Appeal Decision

Appeal Ref: APP/Z4718/Y/21/3280656

Jerk Hut, 160 Manchester Road, Longroyd Bridge, Huddersfield, HD1 3JA

- The appeal is made under section 20 of the Planning (Listed Buildings and Conservation Areas) Act 1990 against a refusal to grant listed building consent.
 - The appeal is made by Cardtronics UK Ltd, trading as CASHZONE against the decision of Kirklees Metropolitan Borough Council.
 - The application Ref 2021/65/91672/W, dated 22 April 2021, was refused by notice dated 17 June 2021.
 - The works proposed are the retention of an automated teller machine and associated signage.
-

PROPOSED ELEVATION

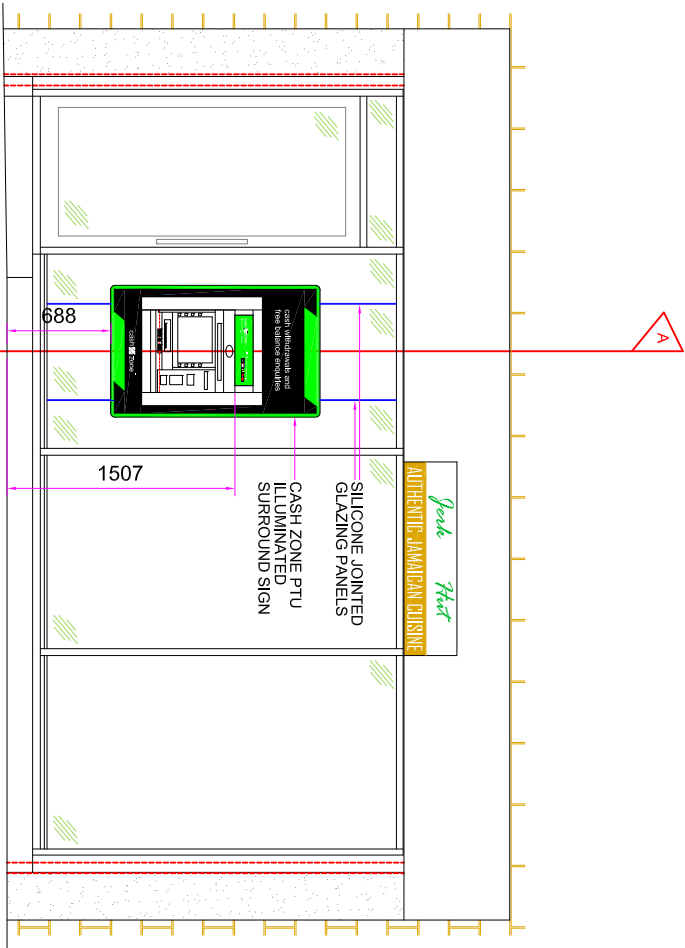
7. The proposed automated teller machine is overtly modern in its appearance and materials, as are the incorporated plastic illuminated advertising panels. Whilst their proposed insertion within the modern glazed shop front means that no historic fabric would be affected, the visual effect on the historic character of the building is nonetheless significant. It would contrast with the traditional design and materials of the existing building, appearing visually intrusive and resulting in less than substantial harm to the listed building. The fact that the works would, theoretically, be reversible does little to mitigate the harm that would arise.
